**OUFC Planning Application Ref: 24/00539/F**

## **Proposed Transport Strategy**

### **From: Friends of Stratfield Brake (FoSB)**

**This is an objection to the applicant's proposed transport strategy. Transport is a key area of concern for us.**

LOCATION PLAN

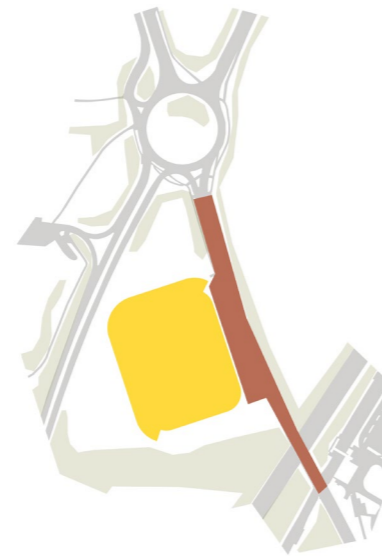
- The applicant's plans include measures to attract fans to the games earlier, and also to stay later, to enjoy the fan zone etc. This could mean the flow of fans is reduced and more prolonged resulting in longer road closures and/or disruption to traffic flow as fans repeatedly use the pedestrian crossings over the Oxford Road.

- The proposed Toucan crossing on Frieze Way can also be expected to be in substantial demand for people accessing the stadium from Kidlington. This would also have an adverse impact on traffic flows. Similar comments apply to the Toucan crossing on the Oxford Road.

ILLUSTRATIVE MASTERPLAN

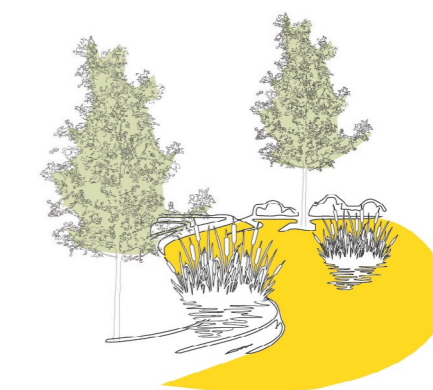
- The Design Review Panel's Summary of Recommendations includes "*Concerns about the proposed main entrance handling large crowds & level differences from the highway*". Factors such as this, resulting from over-development of this small site are likely to slow fan movement down and lead to longer road closures.

- Frieze Way would be one of two main entrances into the stadium site. It is difficult to envisage a scenario where this many (thousands of) fans can be safely delivered without affecting the traffic flow along Frieze Way which will already be operating at a much higher capacity because it forms part of the diversion route.

- The 3m pathway plus .5m buffer zone on Frieze Way (as required by OCC) would appear to mean further loss of vegetation and biodiversity and will affect the BNG metric.
